COMMUNITY SERVICES DEPARTMENT

April 8, 2020

Subject: Creekside South at Lorson Ranch PUD (PUDSP201)

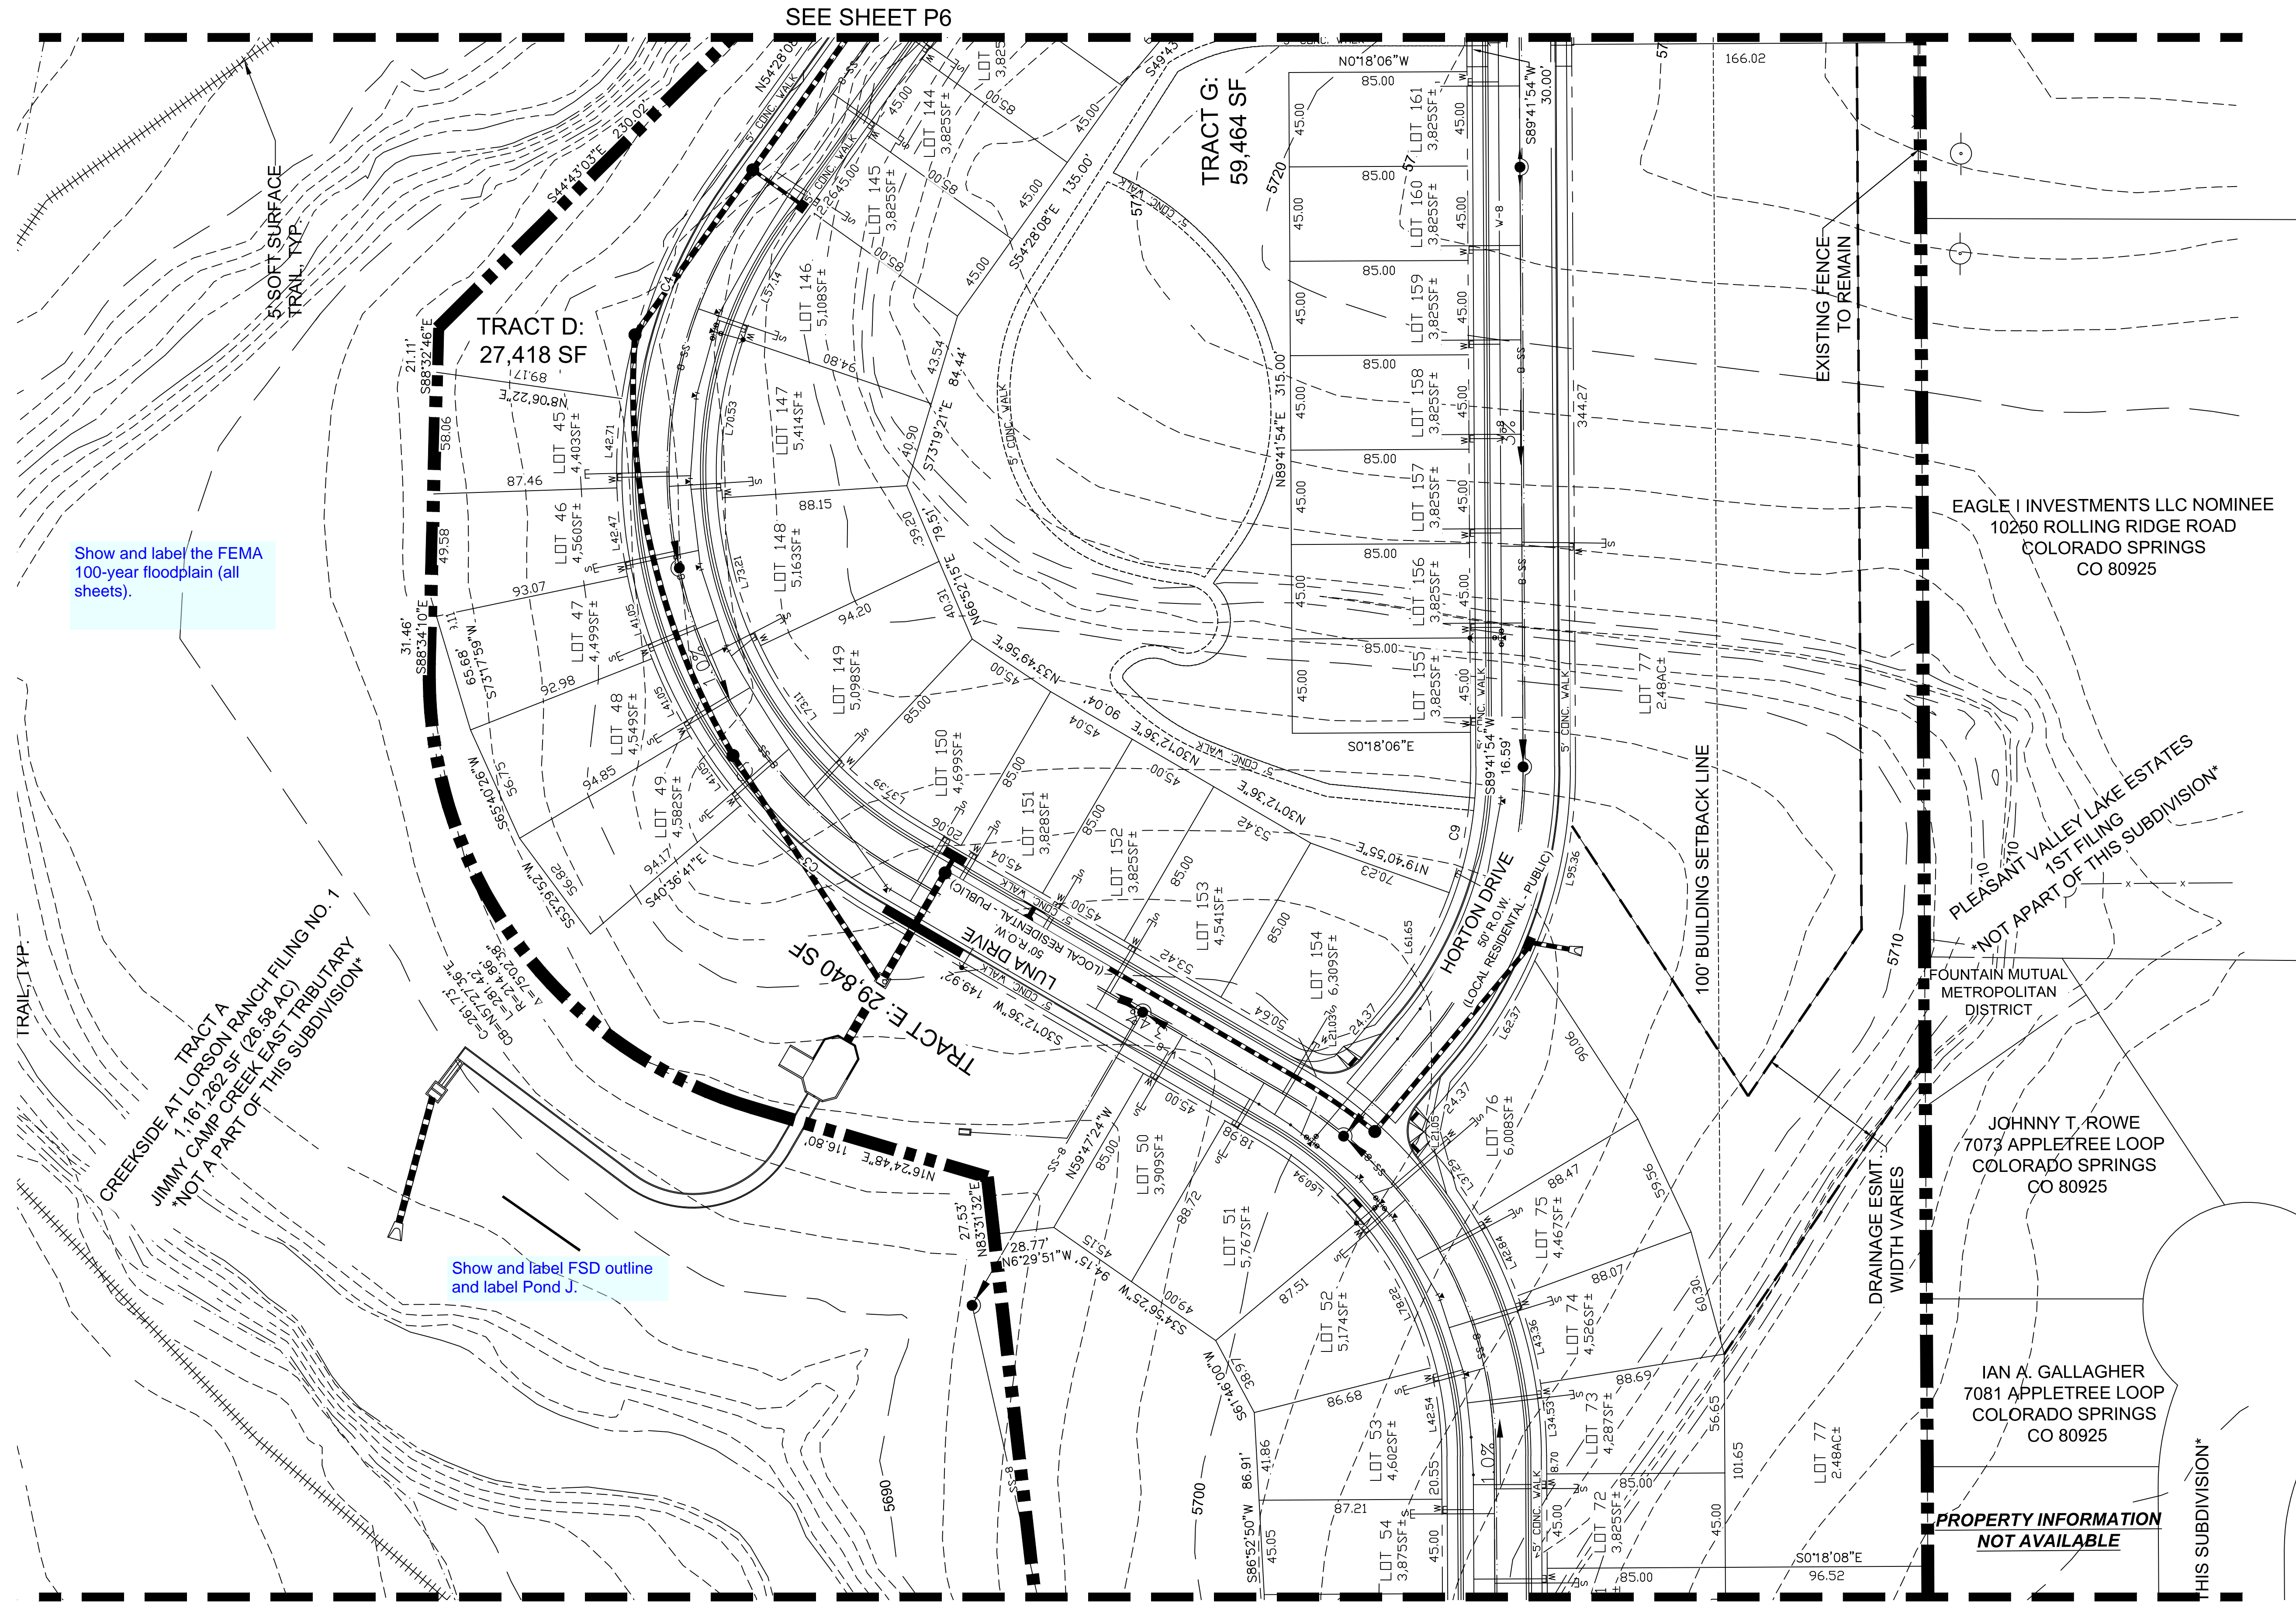
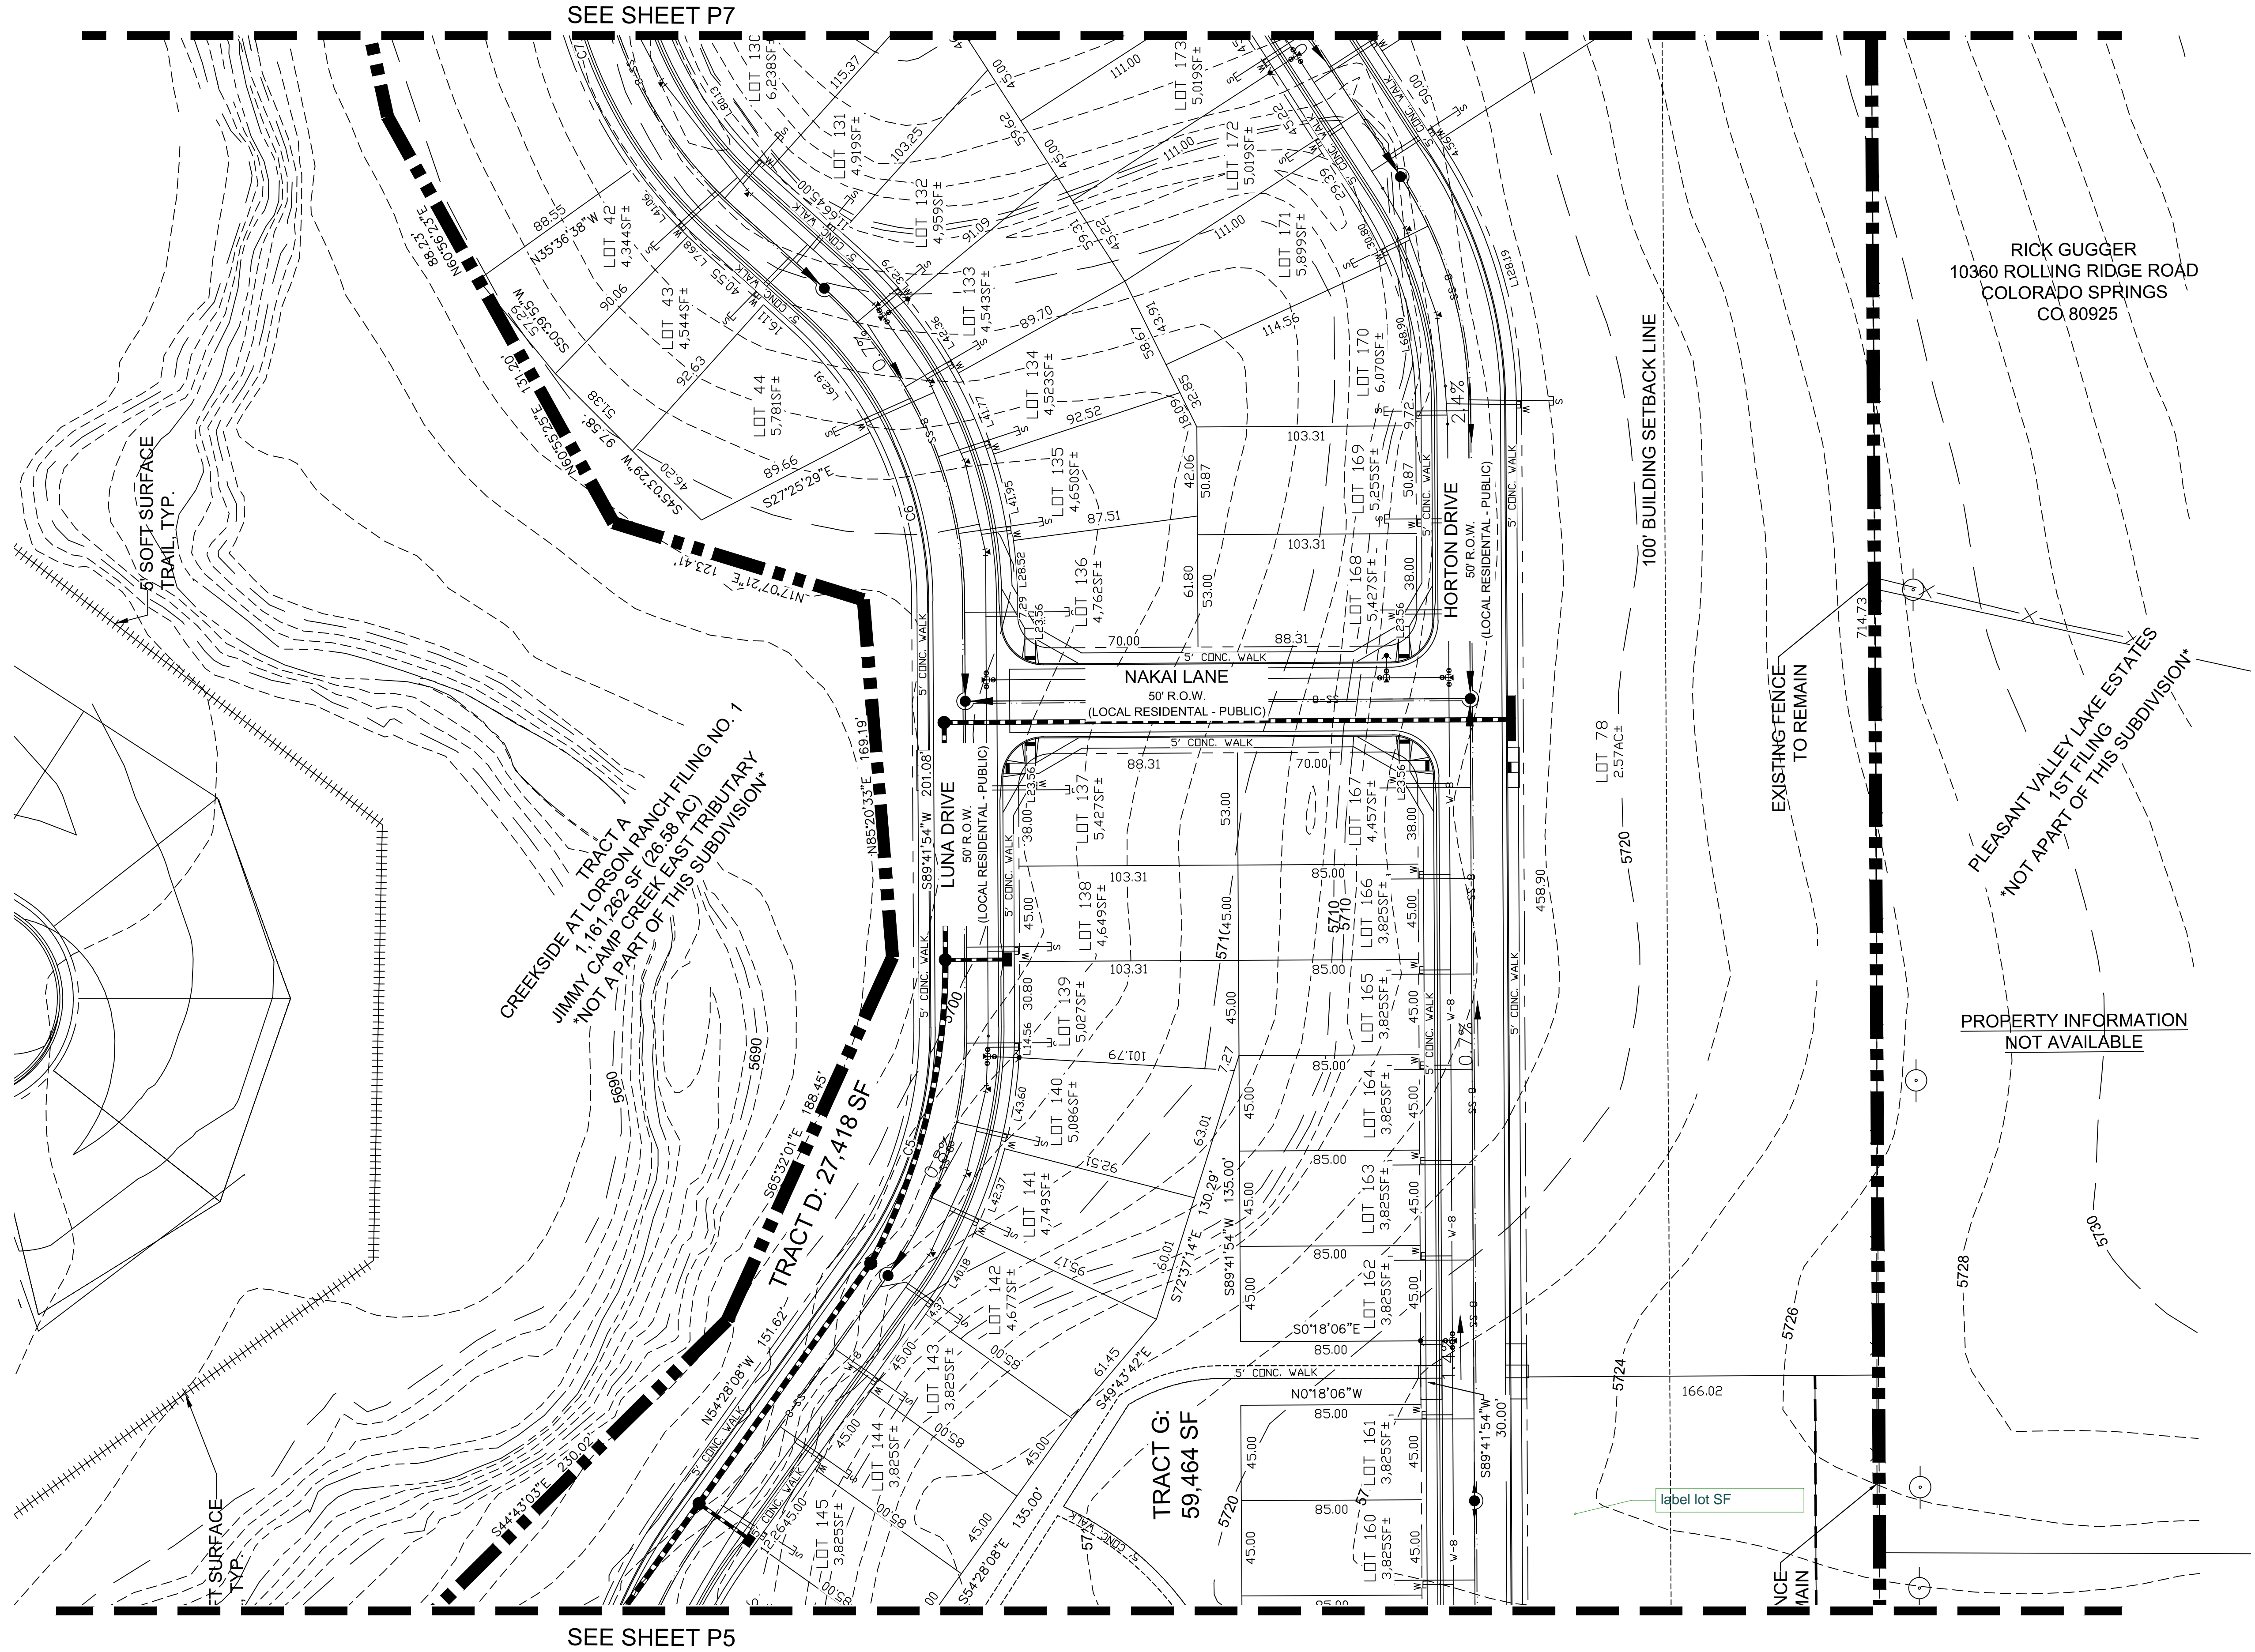
After a review of the Creekside South PUD plans staff notes there are no internal trails shown on the drawings. Staff strongly encourages the applicant provide a trail within the Creekside South PUD area and suggests the continuance of a trail that is shown on the previously approved Sketch Plan and within Lorson Ranch East Filing No. 4. This internal trail follows the overhead electric line corridor, crosses Trappe Drive, and is shown ending within Creekside South at the southern boundary of Lorson Ranch. Staff recommends the applicant continue this trail west through the buffer space adjacent to Horton Drive to provide a trail connection to Creekside South.

Recommend to the Planning Commission and Board of County Commissioners that approval of Creekside South at Lorson Ranch Planned Unit Development include the following conditions: (1) recommend the applicant include a non-County internal trail along the southern site boundary; (2) required fees for regional park purposes total \$93,400 and urban park purposes total \$59,000. However, these fees will be calculated upon review of forthcoming final plats. A park lands agreement may be an acceptable alternative to urban park fees provided the agreement is approved by the County and executed prior to recording the forthcoming final plats.
